| Application number: 2026/90619   |                                                                                  |
| What is the application for?:    | Change of use and alterations to church (class F1) and Sunday school to form 8 r |
| Address of the site or building: | United Church Marsden, Warehouse Hill Road, Marsden, Huddersfield, HD7 6AB       |

| <p>Planning Application Reference: 2026/90619<br/>Planning Objection – Balcony &amp; Parking Concerns</p> <p>I wish to object to the proposed development, specifically the addition of a raised rear balcony.</p> <p>The submitted drawings confirm that the proposal includes a balcony set within the roof slope, with a glass balustrade. This would result in severe and unacceptable overlooking of my property.</p> <p>The balcony directly faces my rear garden and habitable room windows at an approximate distance of only 8 metres. From this elevated position, with no effective screening due to the transparent balustrade, there would be clear, direct views into both our private garden and the rear windows of our home.</p> <p>Photographs submitted with this objection clearly demonstrate the close and direct relationship between the prop

Proposed Site Plan
Scale 1:200

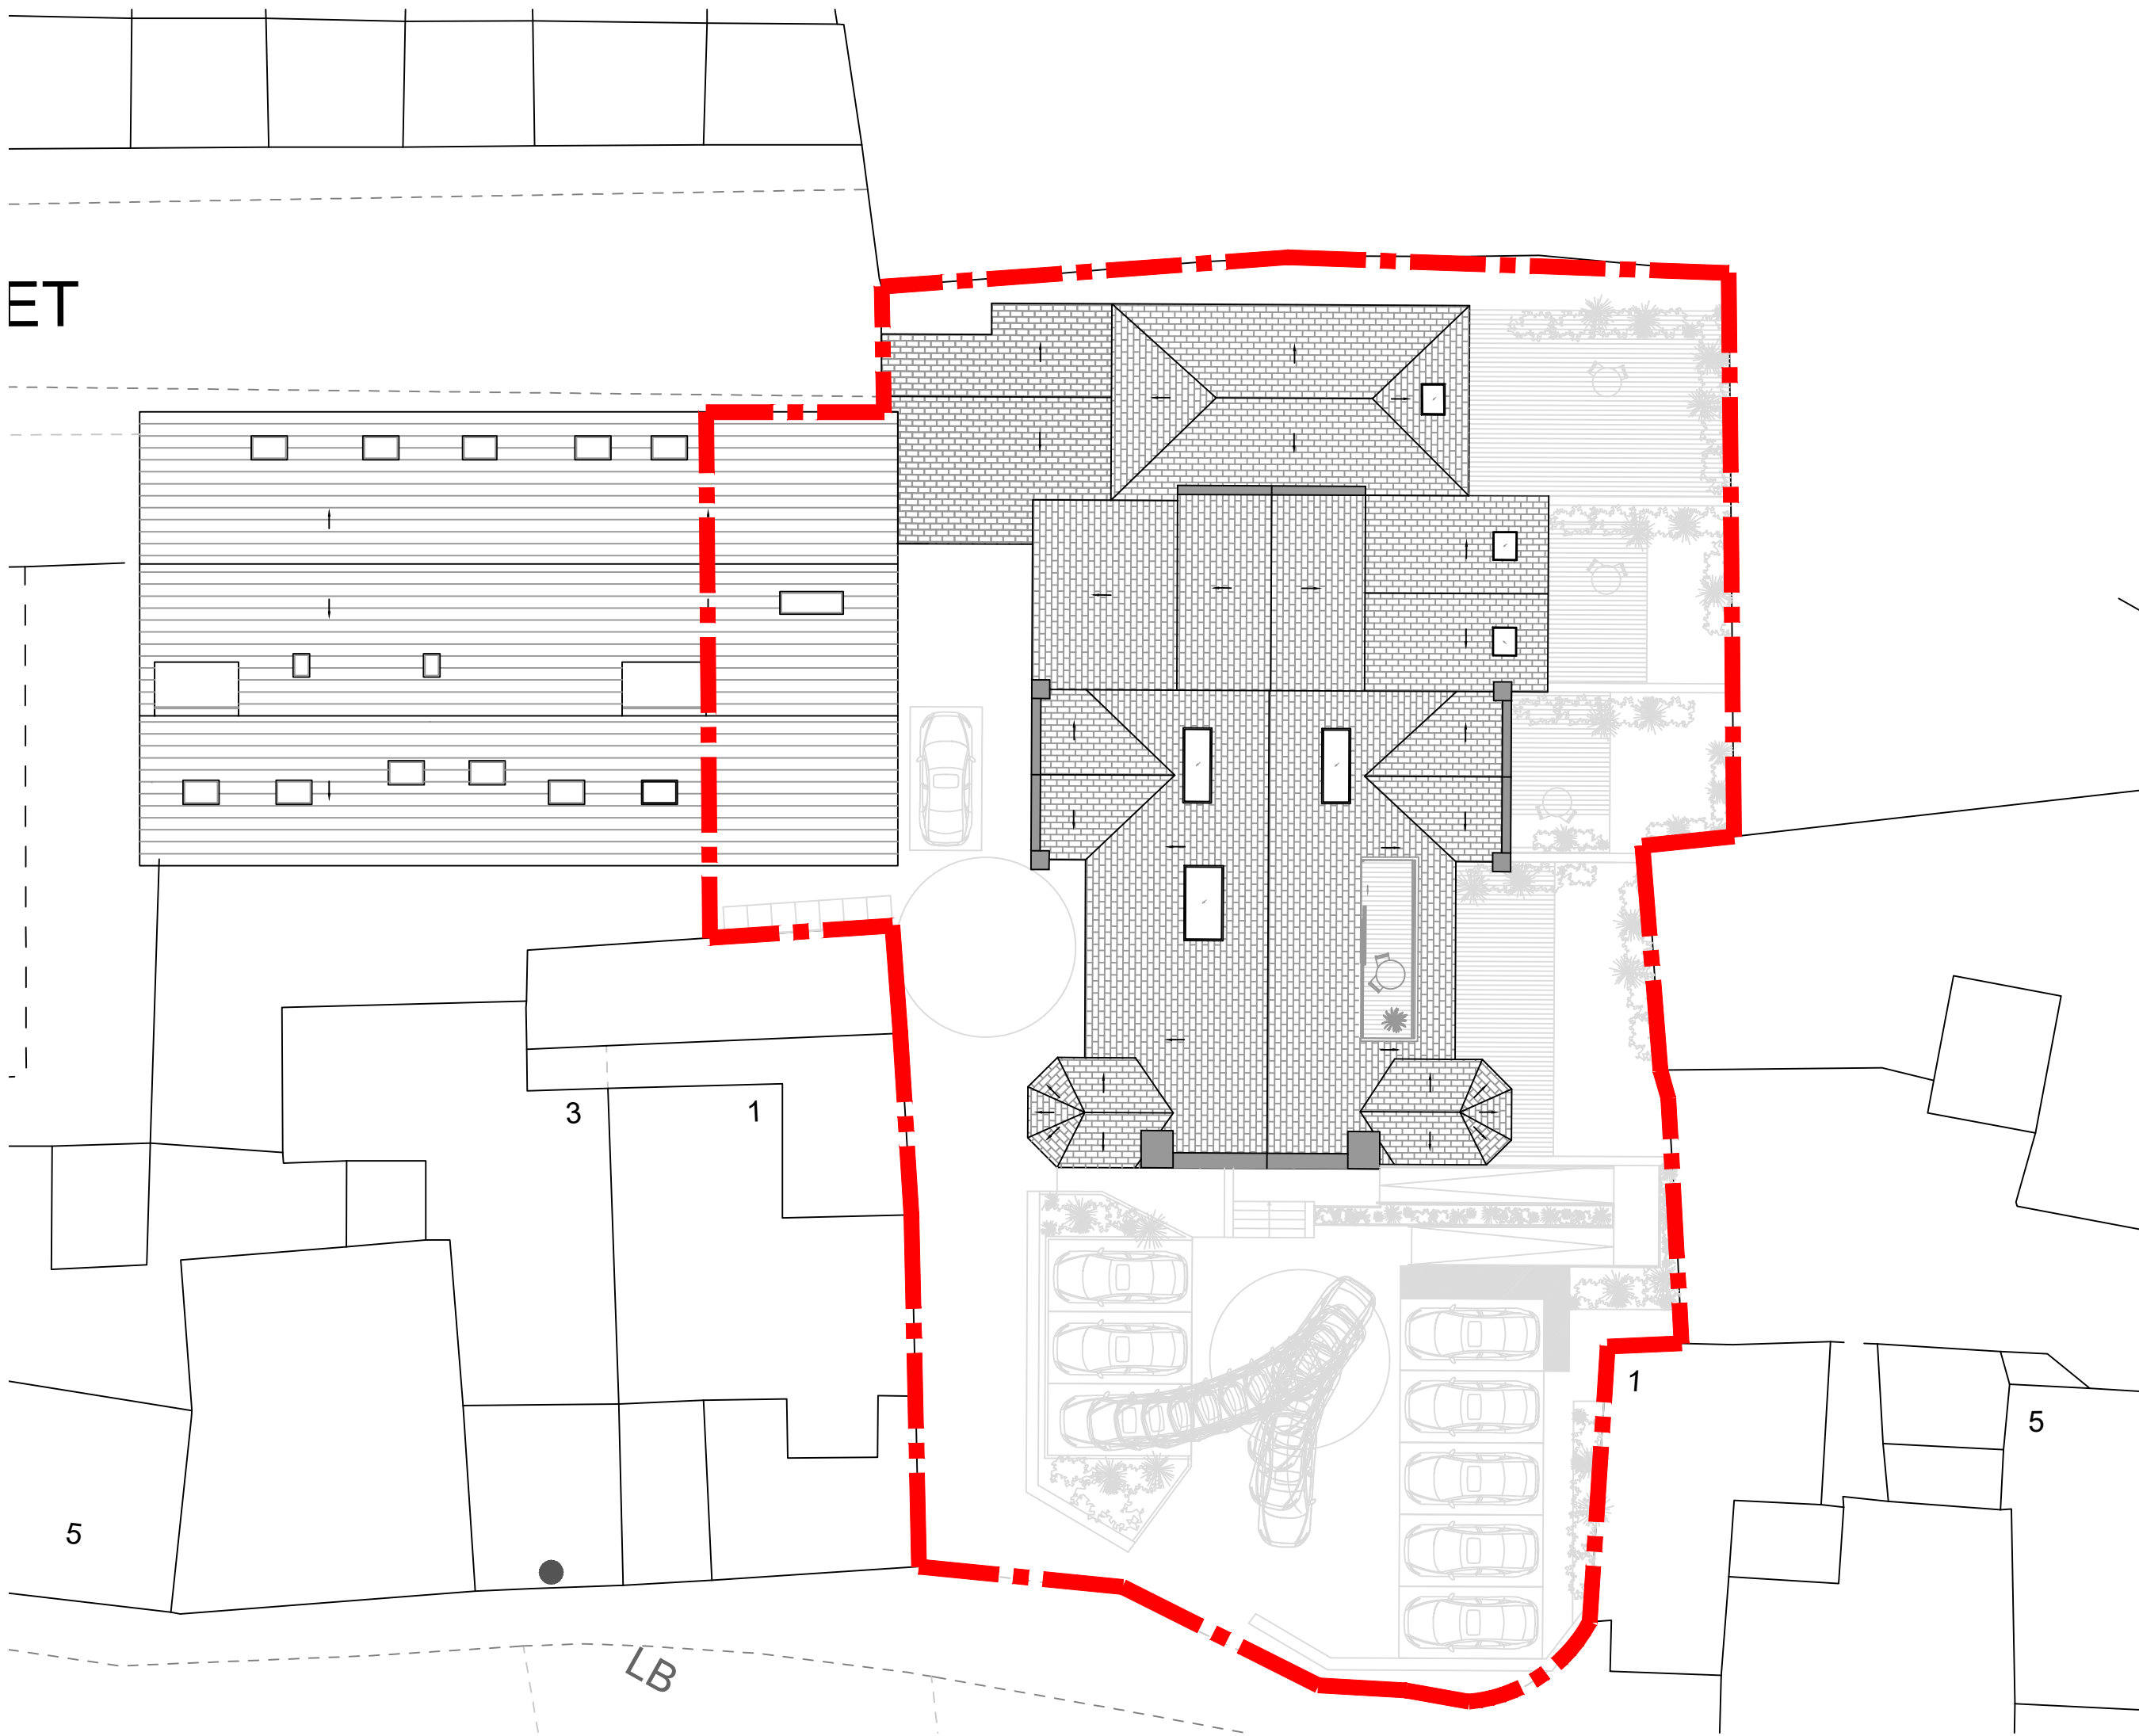
In addition, I have concerns regarding parking provision and access. The proposed development appears likely to increase the number of vehicles associated with the site, and it is unclear whether sufficient off-street parking is provided.

As per local planning policy, a minimum of 2 spaces per 2- to 3-bedroom unit is recommended. The redevelopment consists of 5 units with 2 bedrooms and 3 units with 1 bedroom. Assuming one space per 1-bedroom unit, there is a need for 13 spaces. The redevelopment currently provides only 9 spaces and no visitor parking.

The inadequate parking will exacerbate existing parking issues, as additional cars will potentially be parked on Warehouse Hill, blocking a driveway and parking on the dropped/lowered kerb, which results in pedestrians on the highway.

title:
Proposed Site & Roof Plan

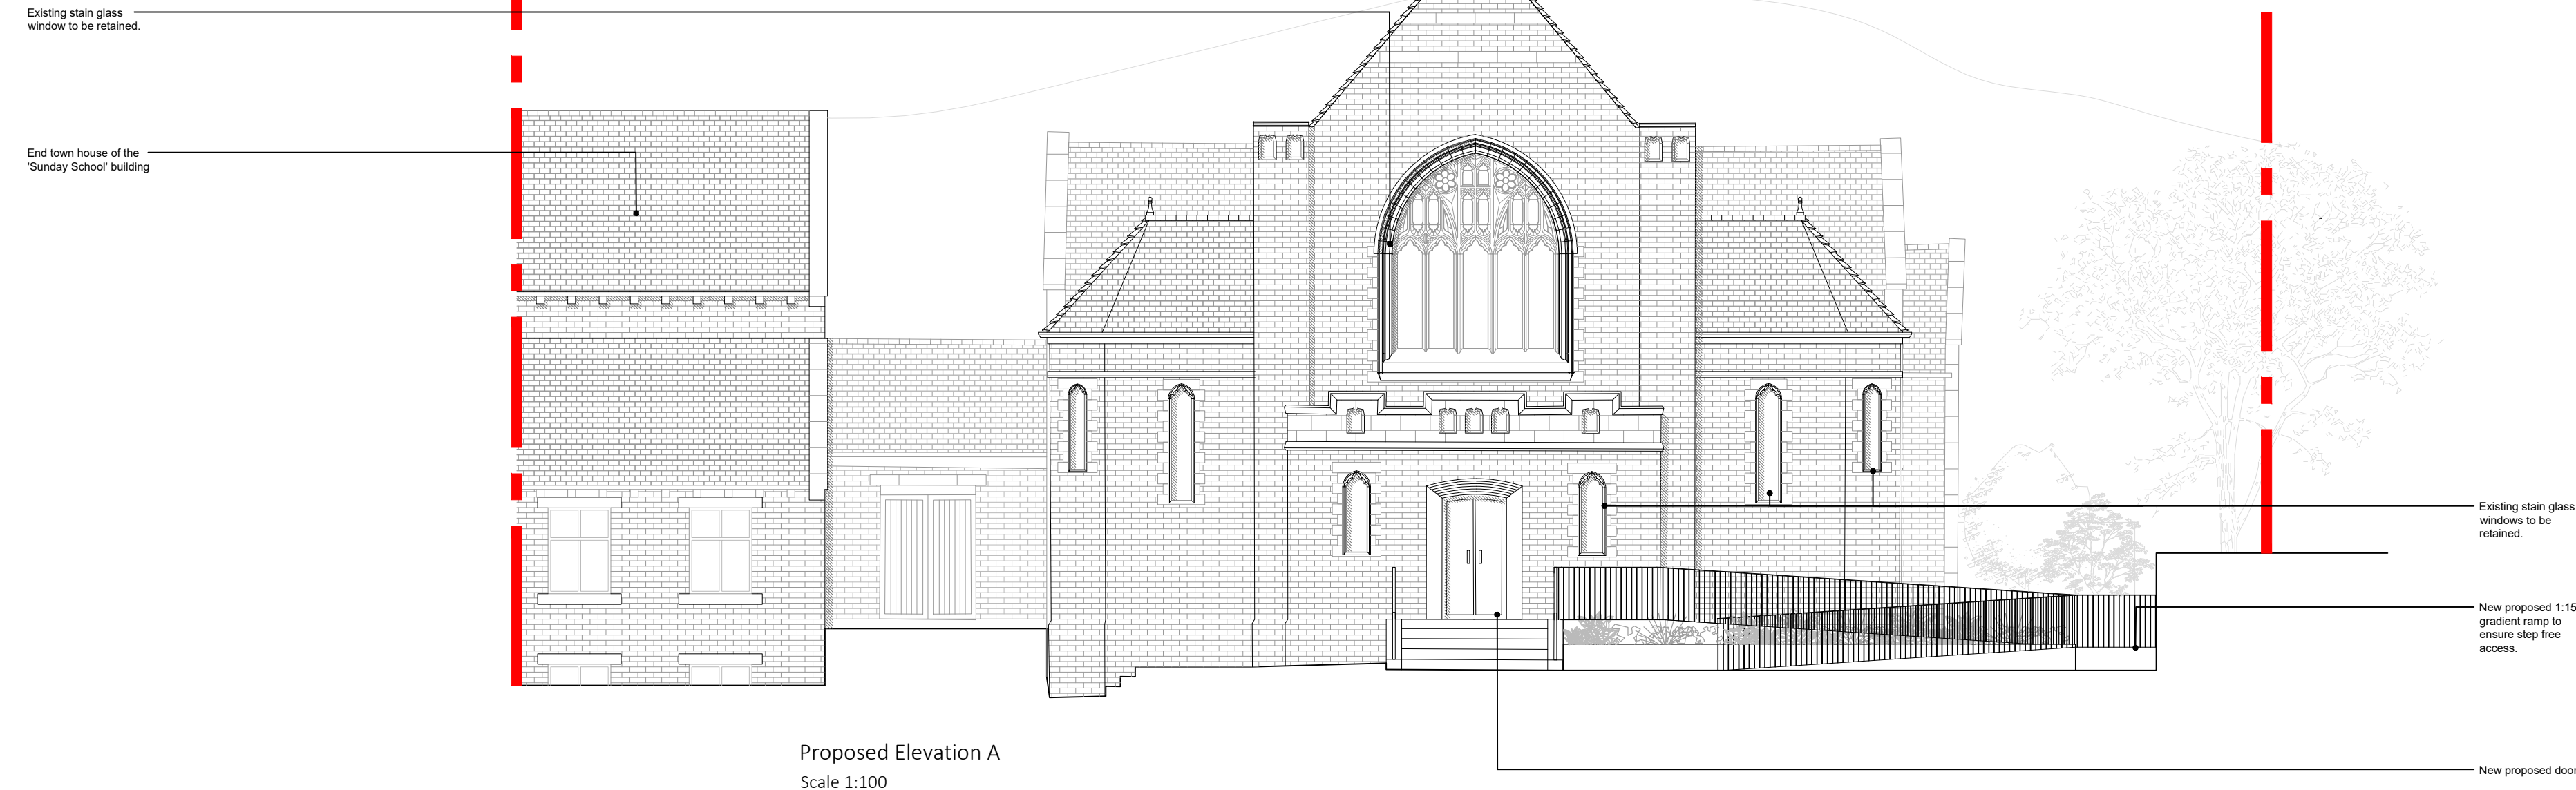
windows potentially) This constitutes a substantial invasion of my private amenity, as per local policy, which states that extensions and alterations should consider the impact on the amenity of residents in neighbouring properties and should cause no harm. The proposed roof balcony would result in a significant invasion of privacy.

Furthermore, using the balcony as an outdoor seating area would likely increase noise and disturbance, further compounding the harm.

Importantly, it appears that the balcony could be reasonably repositioned to the opposite side of the building, thereby avoiding direct overlooking of neighbouring gardens and windows. This demonstrates that a less harmful alternative exists.

For these reasons, I strongly request that planning permission be refused or that conditions be imposed requiring the balcony to be moved to the opposite side of the roof space.

If the Council is minded to approve the application, I request that robust, permanent privacy screening be required and that the design be amended to prevent overlooking.
